# CITY OF ALBUQUERQUE

**Re: Paragon Electric, 1409 Ortiz Drive  
Request For Permanent C.O.  
Engineer's Stamp Date: 10-09-12 (L18/D030)  
Certification Date: 10-18-13**

RE: Additional information, Final As-built, Grading and Drainage Plan, Paragon Electric (L-18/D030)

RE: Final As-built, Grading and Drainage Plan, Paragon Electric (L-18/D030)

## DRAINAGE AND GRADING PLAN

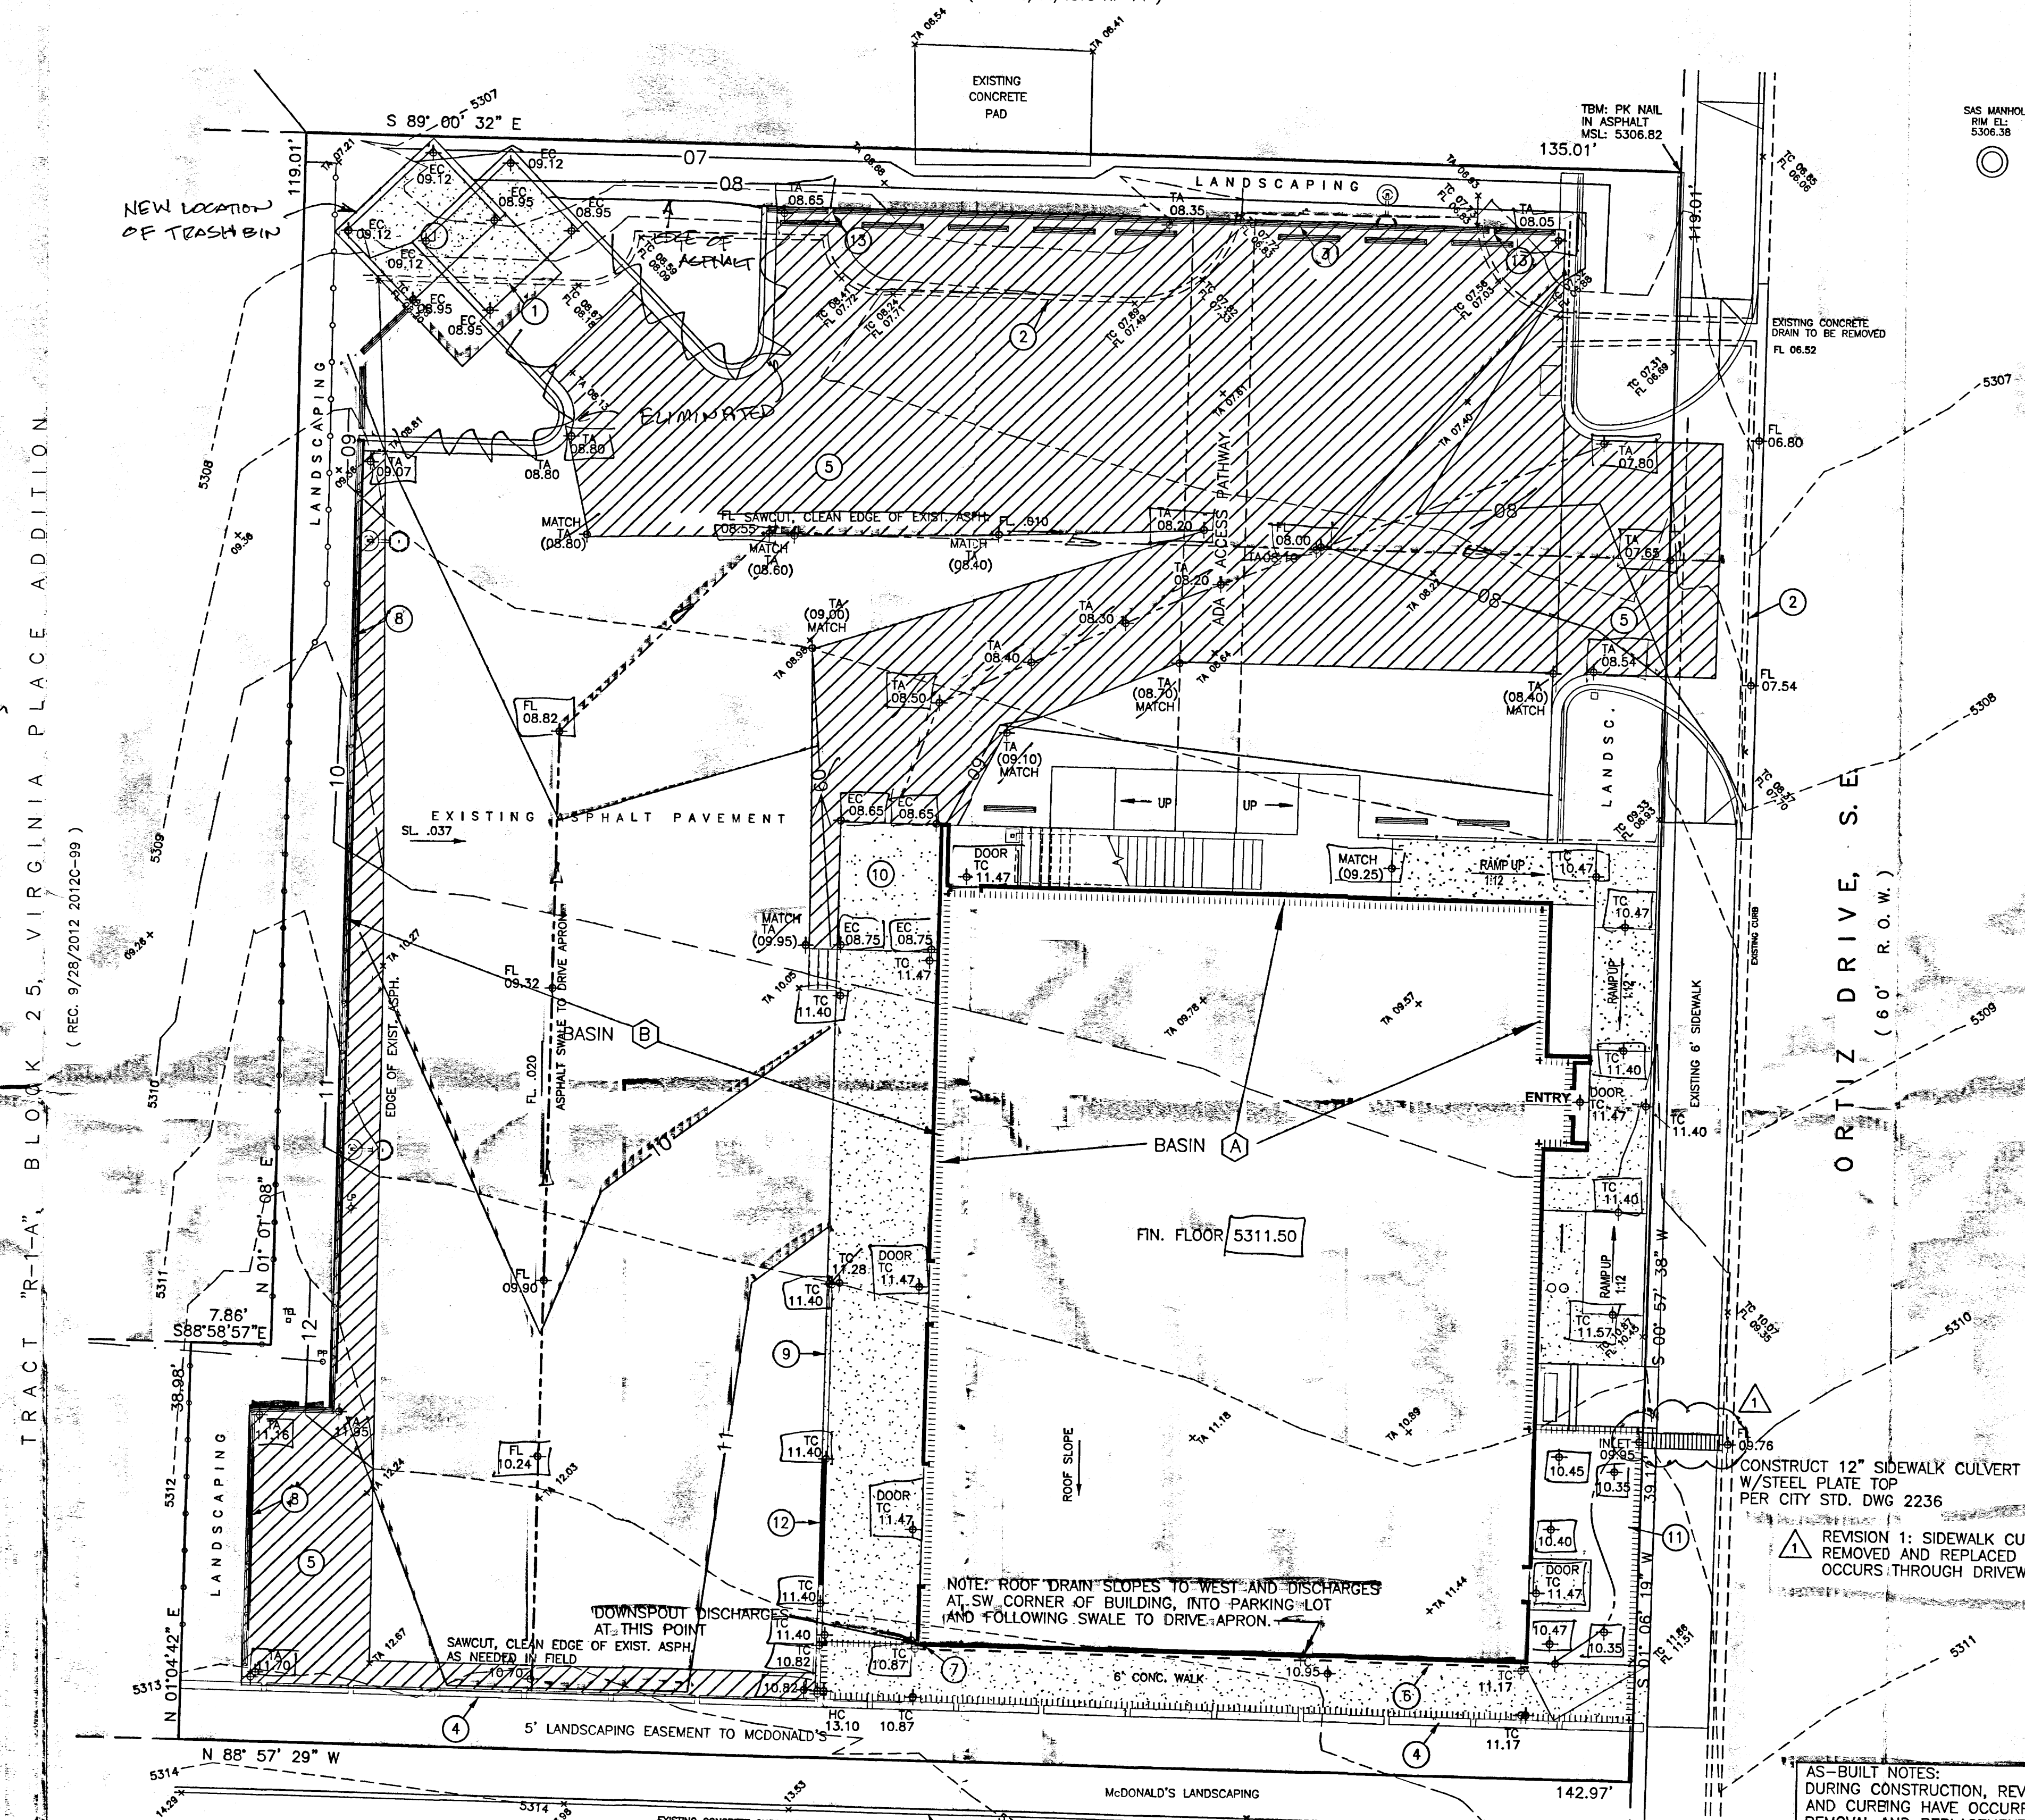
- 1) Change the certification language and include the changes on the drainage patterns from what was approved previously.
- 2) Add more spot elevations around the building.
- 3) How will the runoff drain to the street through the driveway?

We have completed the as-built for Final Certificate of Occupancy for Paragon Electric, 1409 Ortiz Drive, SE. Per our conversation previously, the site plan had changed mid-construction, and a decision was made to remove and replace the existing asphalt. This provided the opportunity to regrade the site to incorporate a swale, which allows the entire site to drain through the driveway apron, and into the landscaping. This allowed us to eliminate the SO-19 sidewalk culvert.

I have changed the certification language per your request. I have also added additional spot elevations in the landscaped area at the southeast corner of the building. I have also added a note that the landscaping area will retain its own stormwater, as there are no additional contributory basins affecting that area.

The runoff from the roof is channeled into a gutter and downspout. The downspout discharges at the southwest corner of the building, into the parking lot, and follows the swale out the drive apron.
